PROJECT TITLE: 4th St. Comm. Bid ZONE ATLAS/DRNG. FILE #: J-14/1053
 LEGAL DESCRIPTION: Portions of Block 5 Pome. Addition / All Block 3 Paris Add
 CITY ADDRESS: 1223 4th St NW

Re: Drainage Plan for 4th Street Comm. Bldg. (J14/D53)

RE: REVISED DRAINAGE PLAN FOR 4TH STREET COMMERCIAL BLDG. (J14-D53)
RECIEVED AUGUST 14, 1985

APPROVALS	NAME	DATE	TITLE: COMMERCIAL BLD. 1223 FOURTH ST. NW ALB. N.M. (ROBERT BUEL, 600 1st NW SUITE 100 PORTION BLOCK 5 ROMERO ADDN.	
A.C.E./DESIGN				
INSPECTOR			PERMIT NO.	MAP NO. 6-14
A.C.E./FIELD			SHEET 2 OF 3

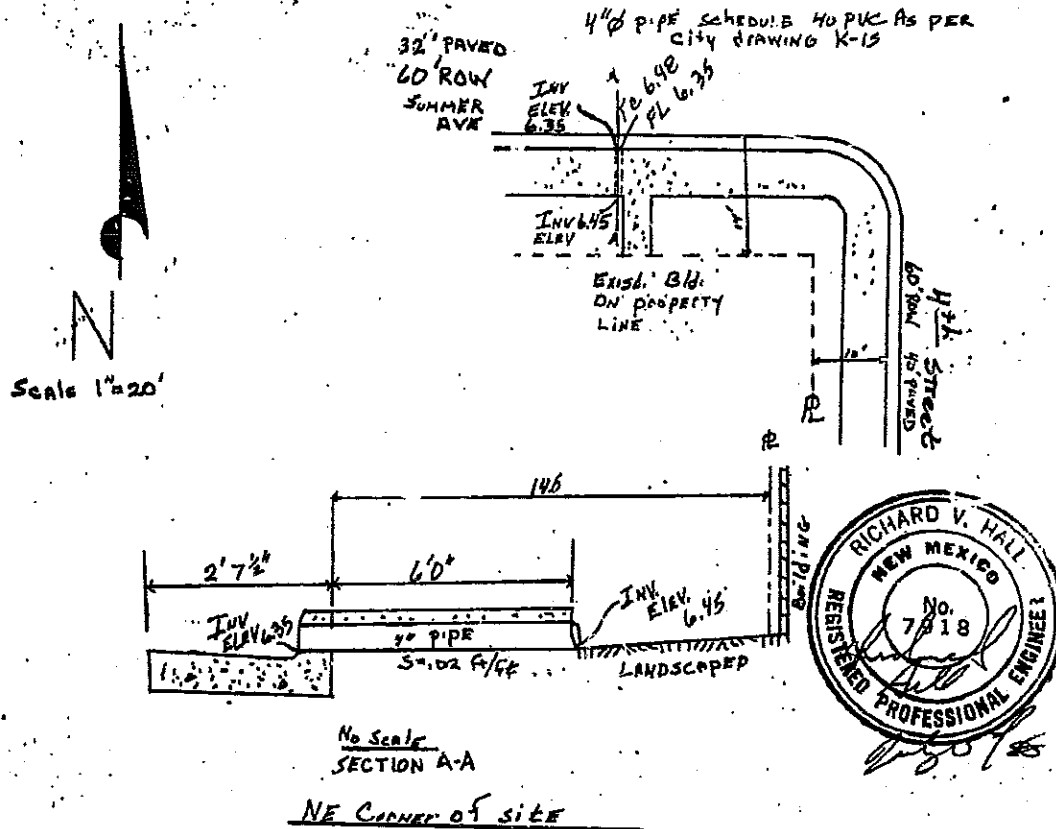
1. It is not very clear as to what is being constructed but I am assuming that it is for the parking lot in the north portion of lots 19-24 of the block and including the alley. If this is correct then a paving permit issued by only this section is appropriate.
2. The drainage analysis for this site is approved. However, prior to Hydrology sign-off the City approved alley grades and improvements will be required. The reason for this requirement is due to the dependency of this site for the use of this alley. Also, the note for erosion control is not appropriate. The note does not provide for a means to keep the exposed soil, during construction, from being wash into the City R/W. A more definitive plan will need to be established for approval.

Please provide a current plat of the property. The zone atlas map does not show a legal alley running north & south through the property.

Also, it appears the paving may be taking place on adjacent property rather than the business property.

In response to the alley not being shown on the zone atlas, I have acquired the information that shows that the alley is city property. The alley is going through the work order process. The letter will show that there will not be paving on the adjacent property, only on the public alley.
